**SECTION 75W MODIFICATION APPLICATION TO MP10_0230
WOOLLOOWARE BAY TOWN CENTRE**

This Section 75W Modification has been prepared to modify the Project Approval MP10_0230 for the Retail/Club Precinct at 461 Captain Cook Drive, Woollooware (Woollooware Bay Town Centre). It is submitted to the Minister for Planning and Infrastructure (or his delegate) pursuant to section 75W and Clause 12 of Schedule 6A of the *Environmental Planning and Assessment Act, 1979* (EP&A Act) by JBA on behalf of Bluestone Capital Ventures No. 1 Pty Ltd (Bluestone).

This modification application relates to minor design modifications to the approved Stage 1 Retail/Club development. Proposed amendments include minor design refinements to the retail development and amended stratum subdivision plans in response to the detailed design of the approved development.

Discipline
Drawing No.
DA011

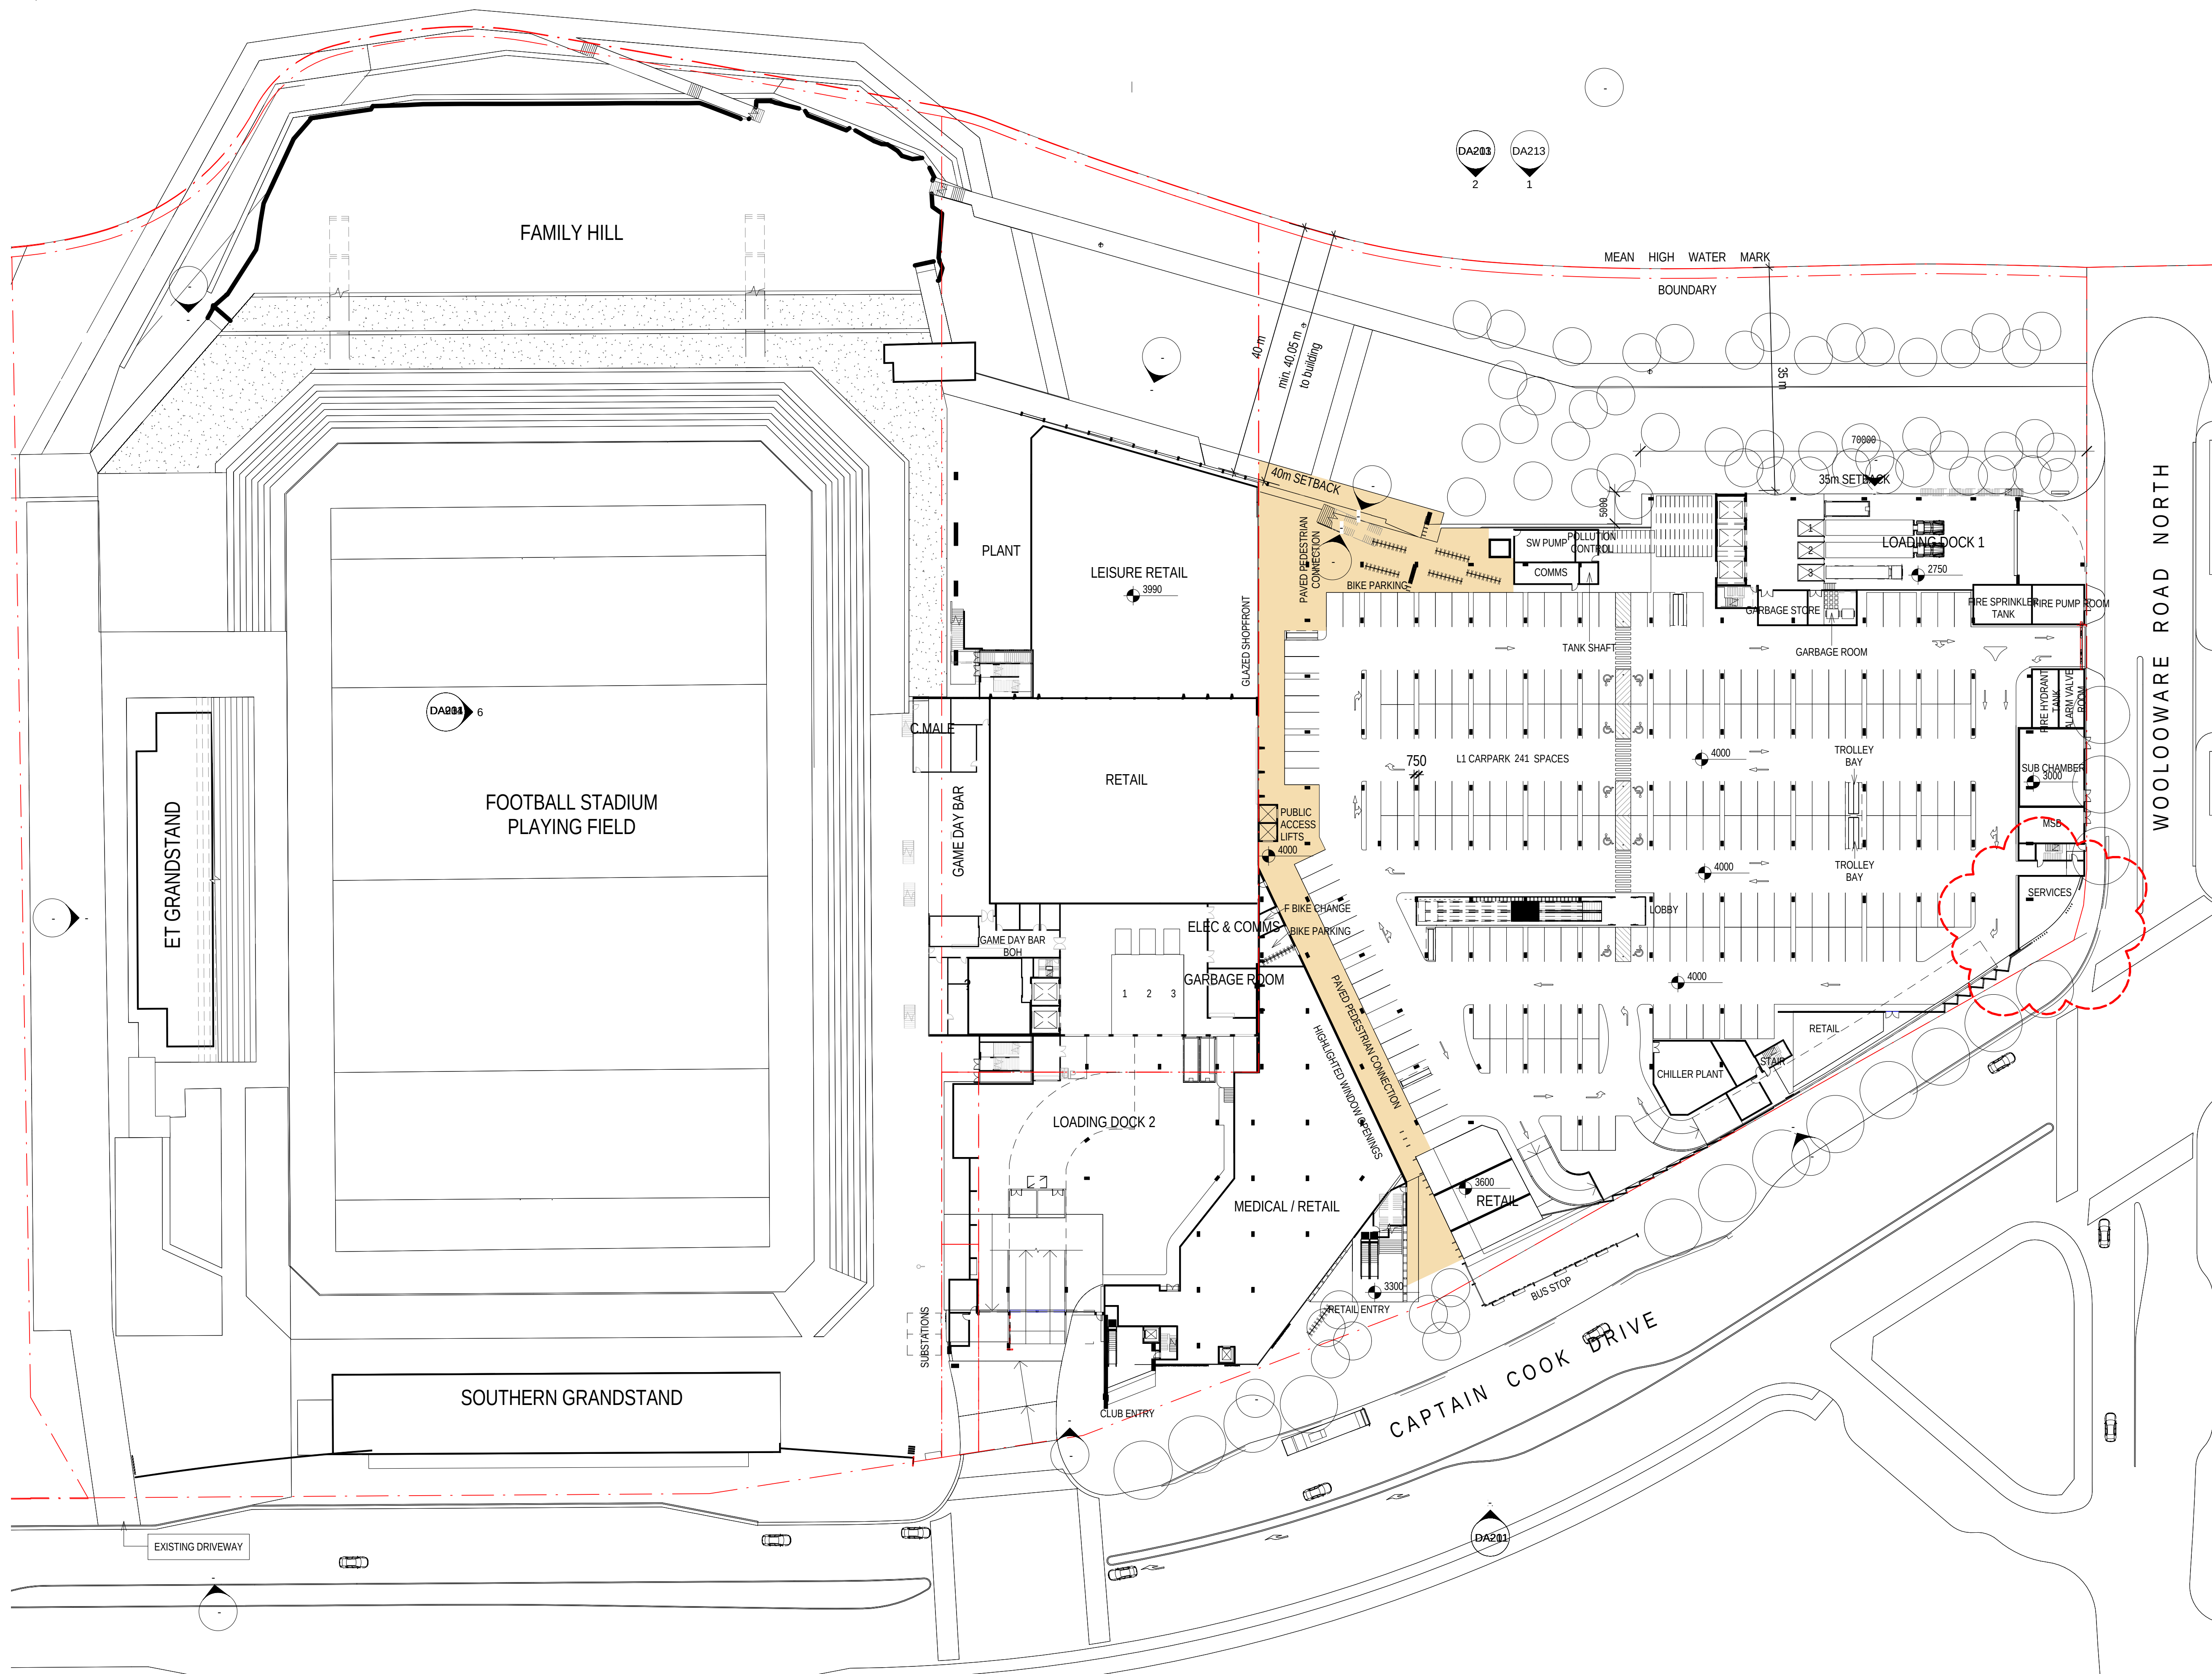
Architectural (or Design) Drawings Prepared by Scott Carver Pty Ltd			
Drawing No.	Revision	Name of Plan	Date
DA011	7	Level 1 Plan	23/05/2013
	9		17/12/2013
DA013	7	Level 3 Plan	23/05/2013
	8		17/12/2013
DA014	4	Level 4 Plan	07/06/2013
	6		17/12/2013

Minor design refinements have been made to the internal layout of the approved retail and club development. Amended Architectural Plans prepared by Scott Carver are provided at **Attachment A**. These changes generally comprise an amended Cronulla Sutherland Leagues Club layout better suited to the needs of the Club. Reconfigurations are proposed to components of the approved club fitout on levels 1, 3 and 4. These include an amended game day bar area on level 1 and the reconfiguration of room layouts on level 3 and 4, including the club restaurant.
